# ENG-PUDSP21005-R2-PDR.pdf Markup Summary

MASTER DEVELOPER AND PRELIMINARY DR. MATTHEW V. CH

POND 1 DETAILS

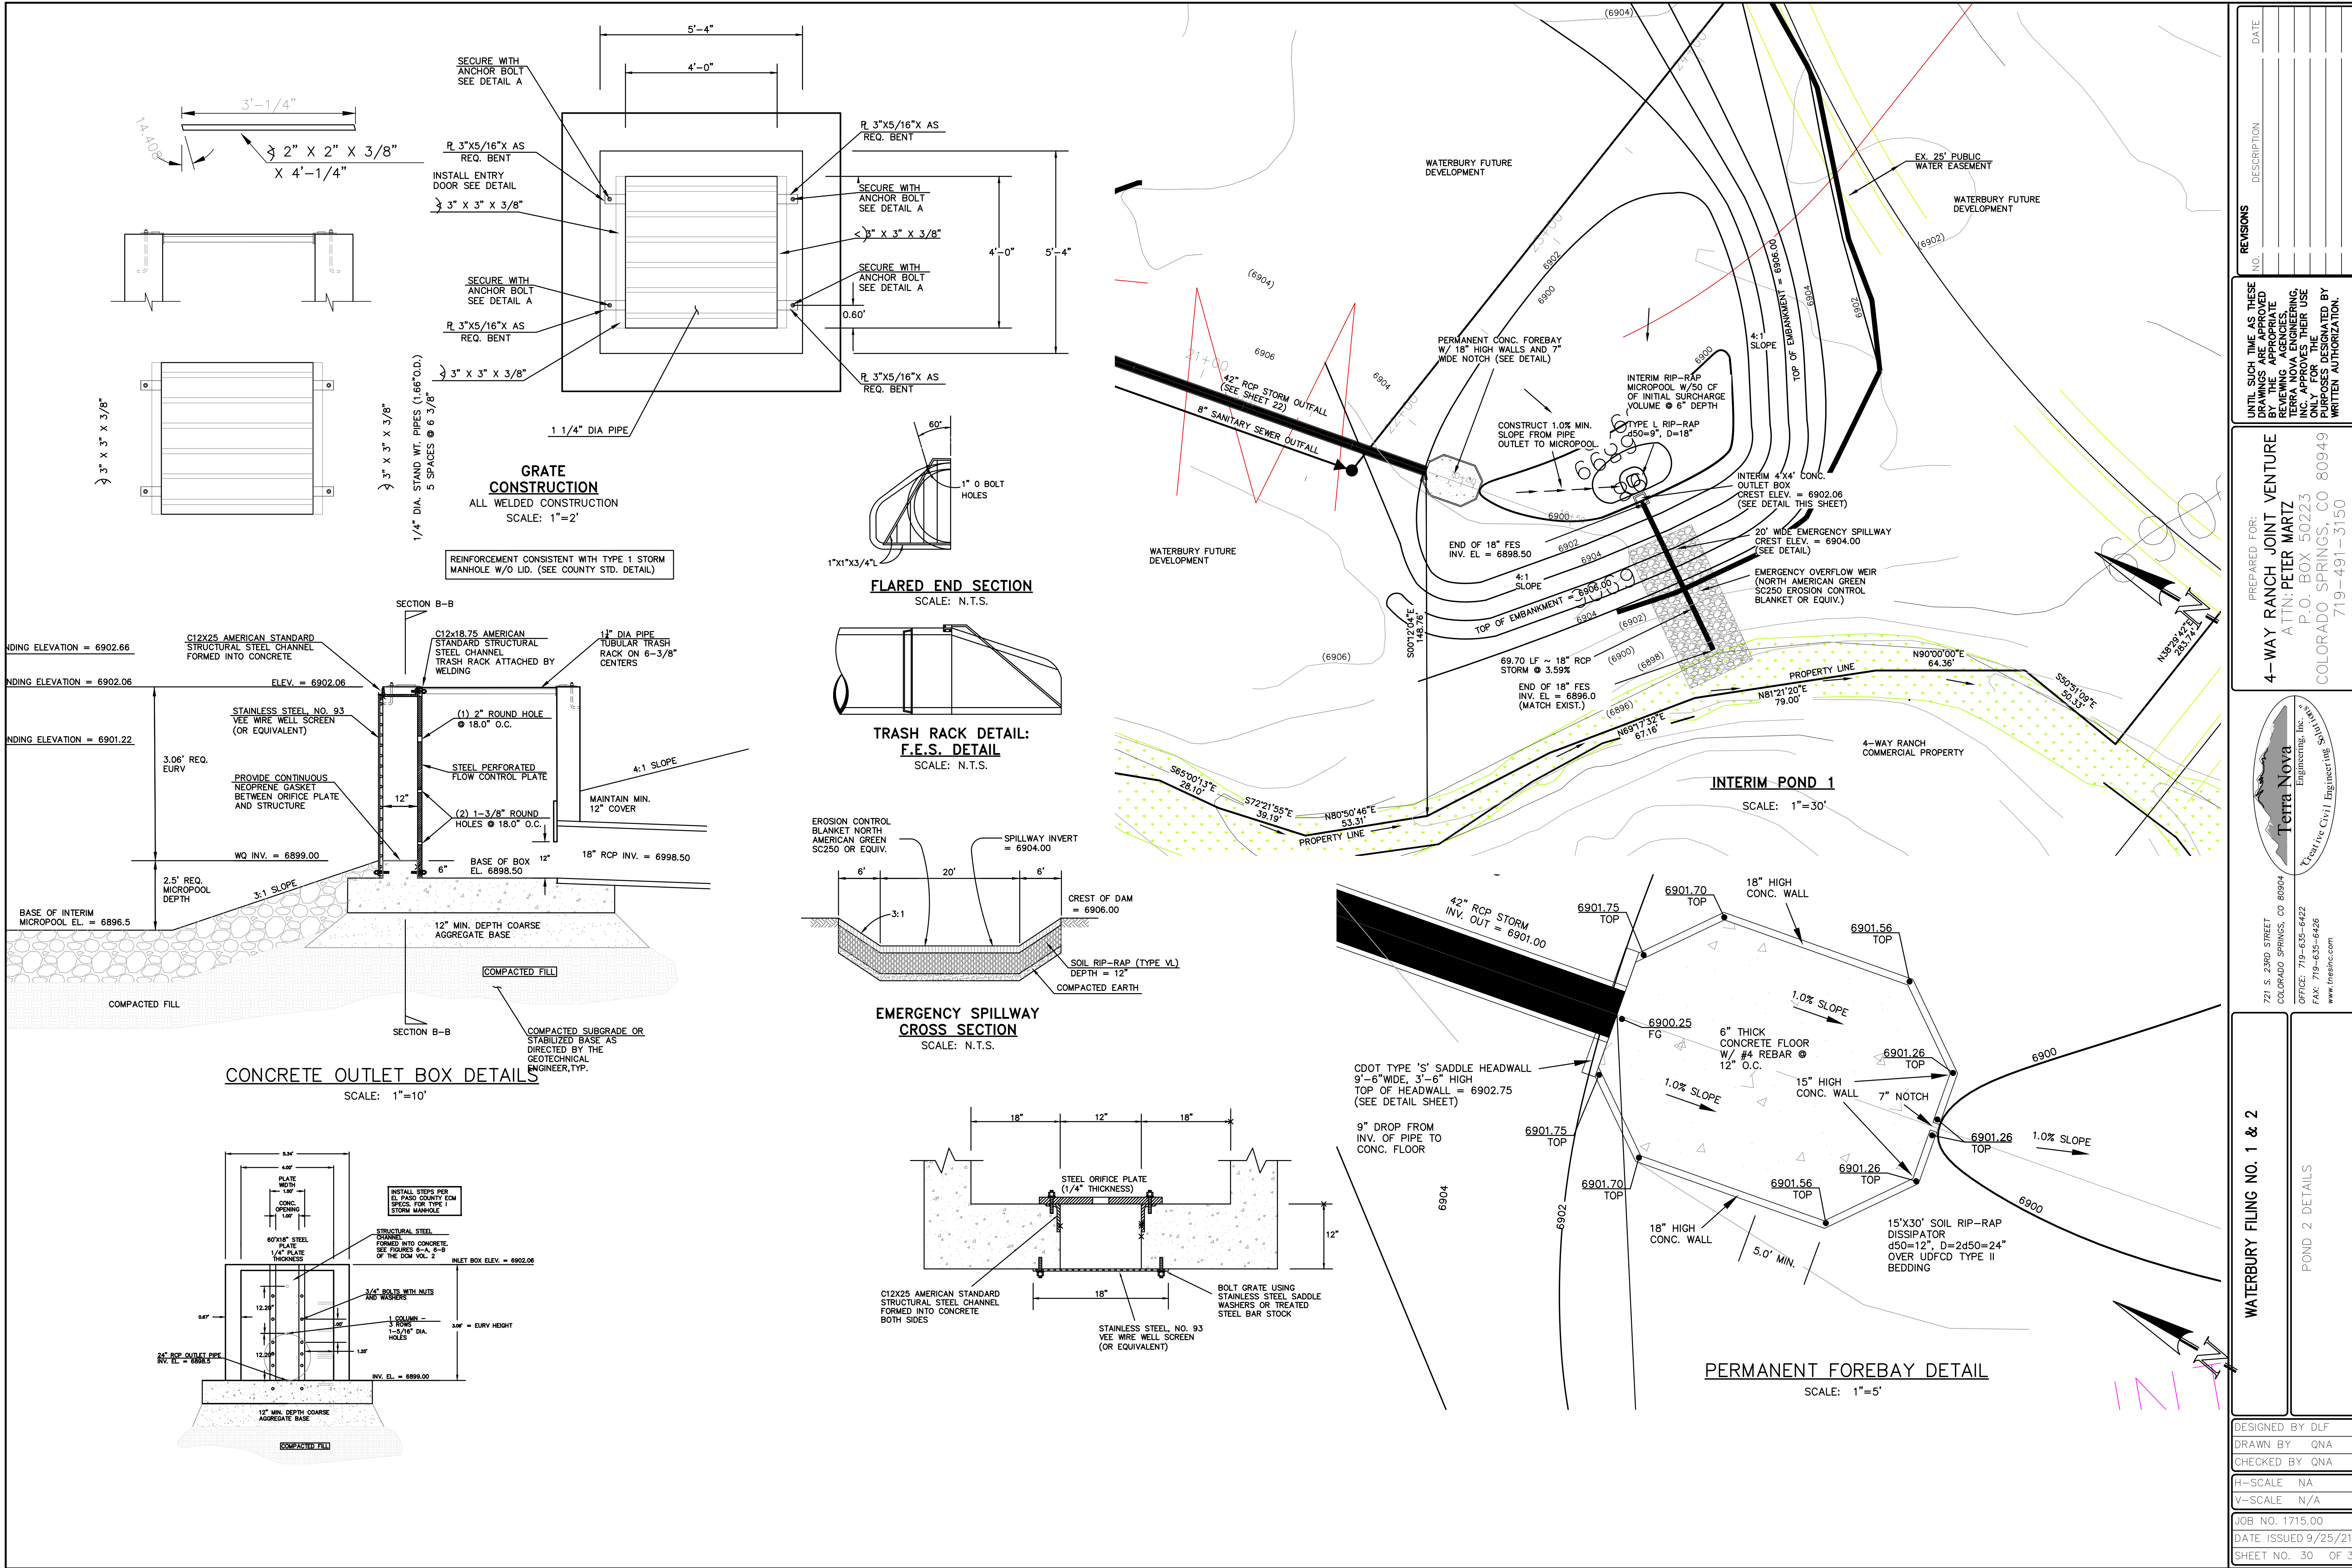
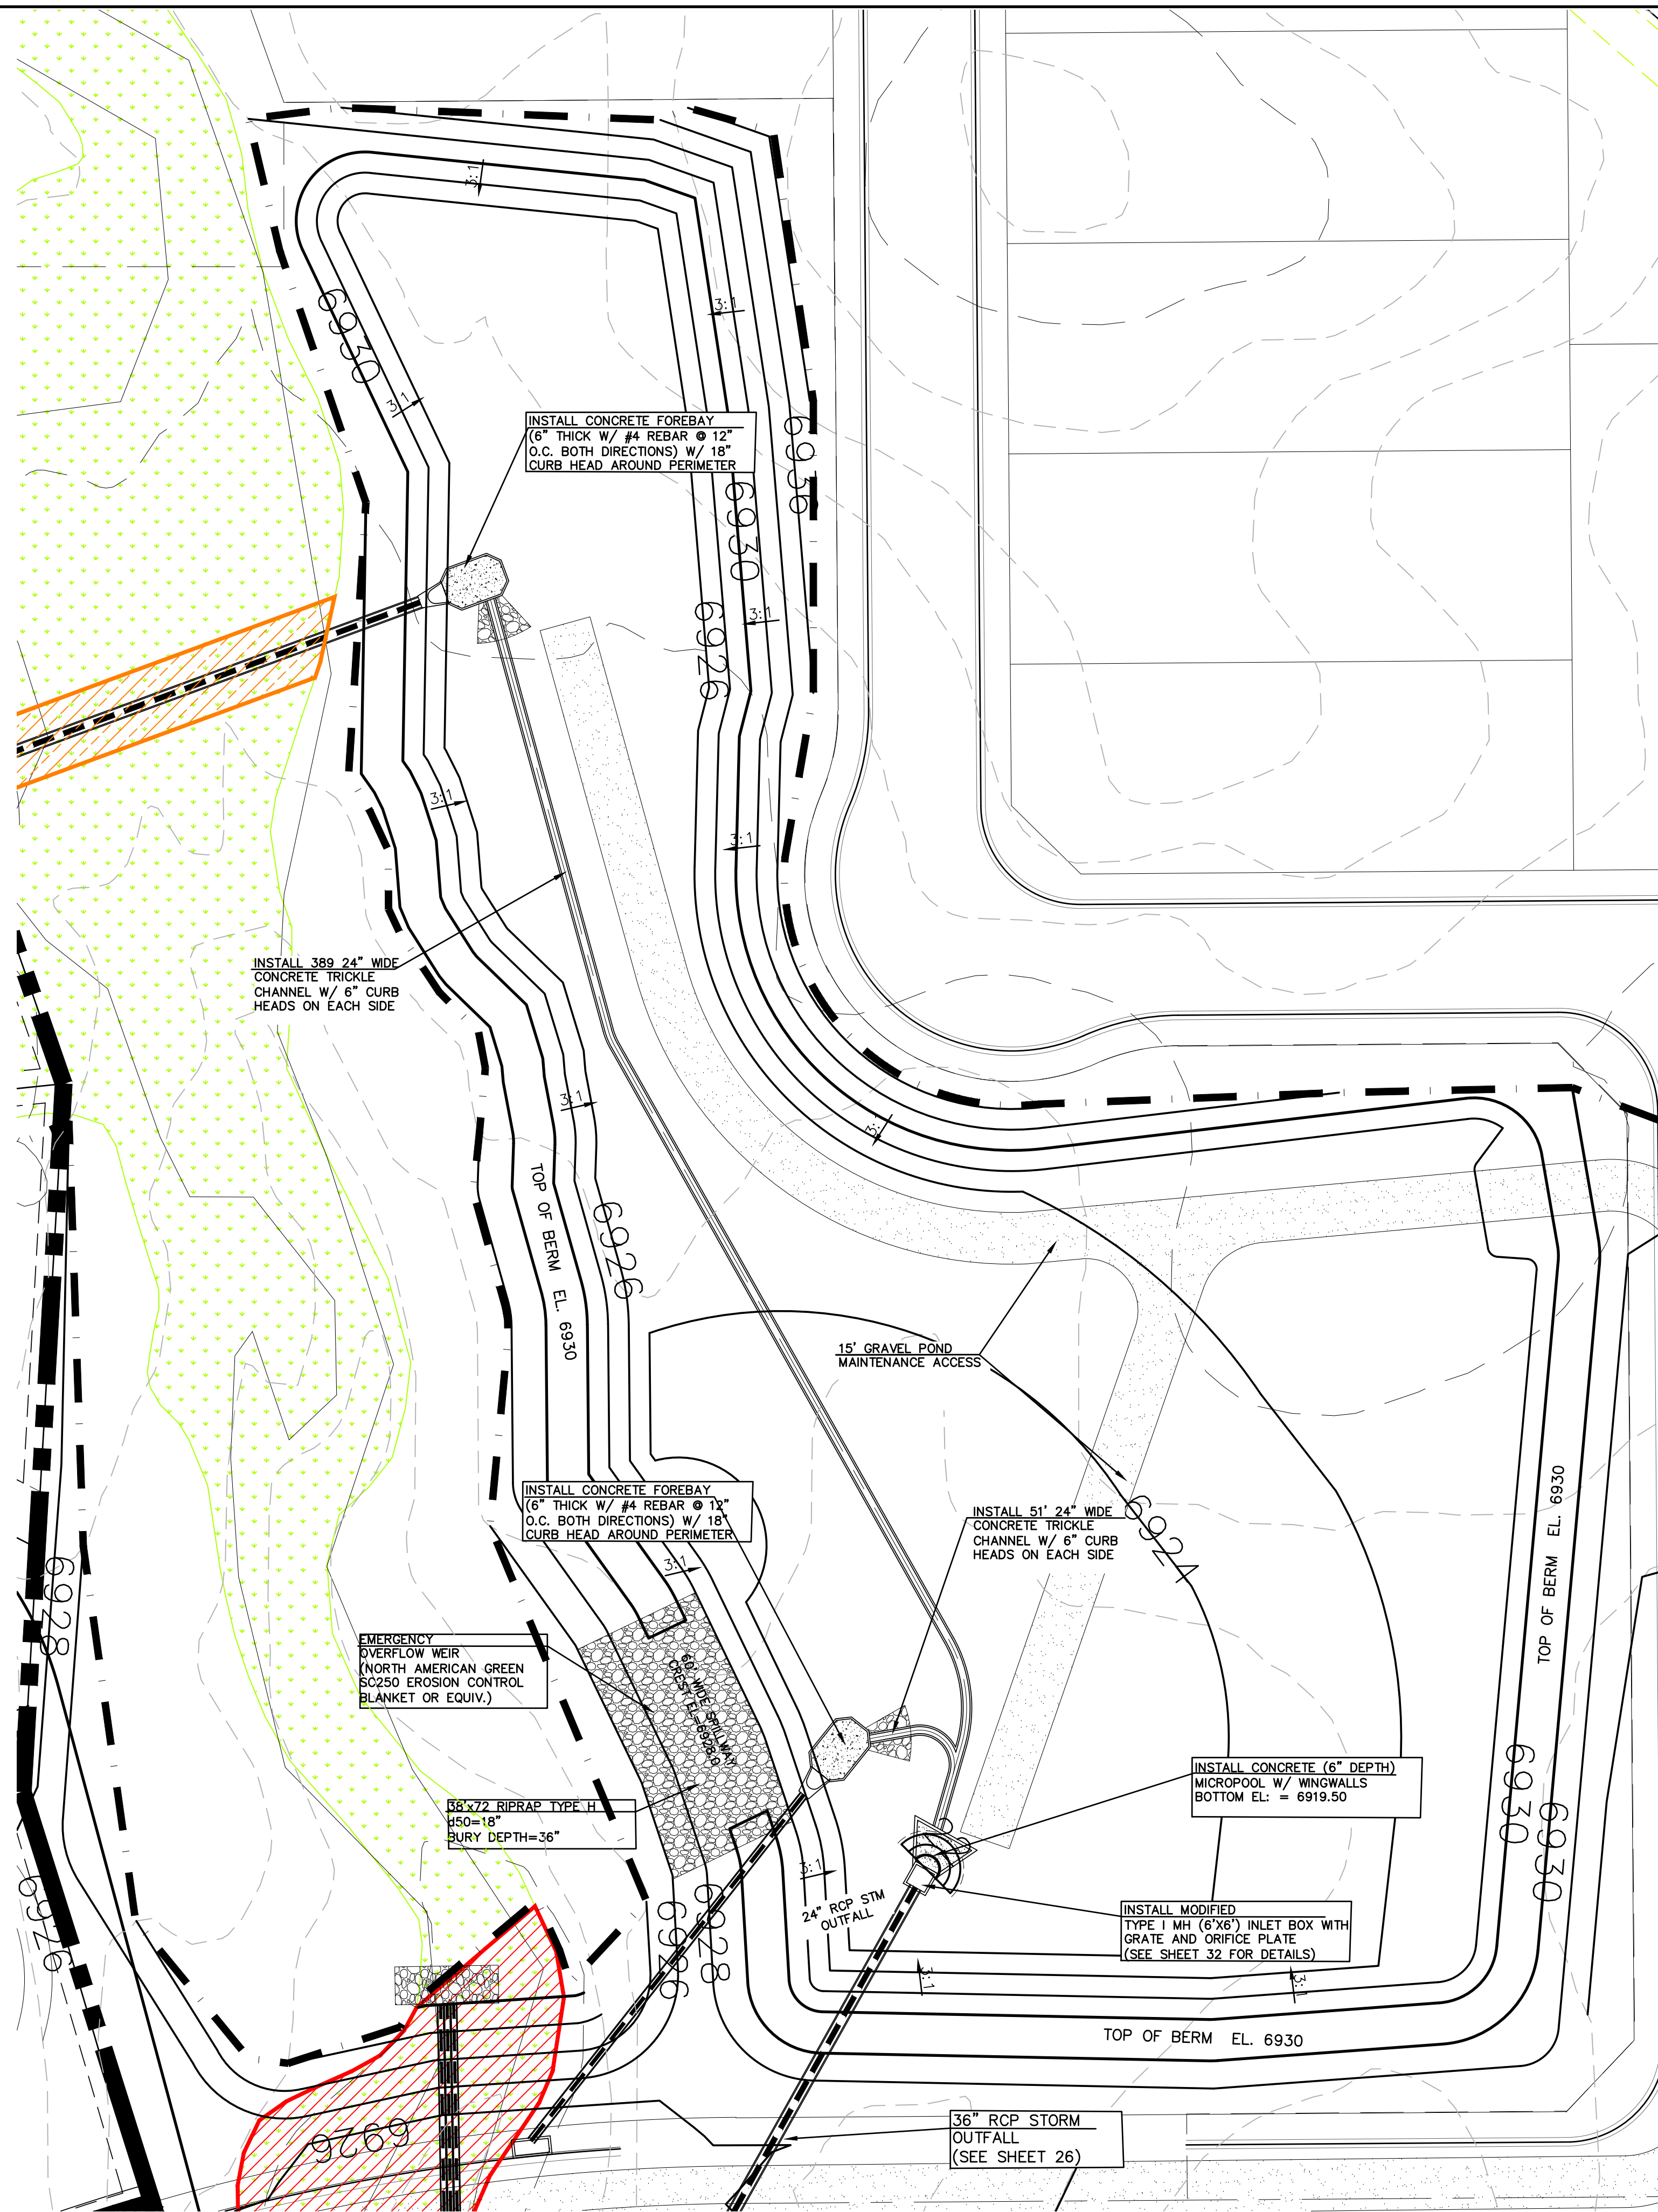
### Calculations for forebay missing in appendix

Clarify if 4x4 is true box dimension or grate dimension. Spreadsheet has grate opening 3' x 3'
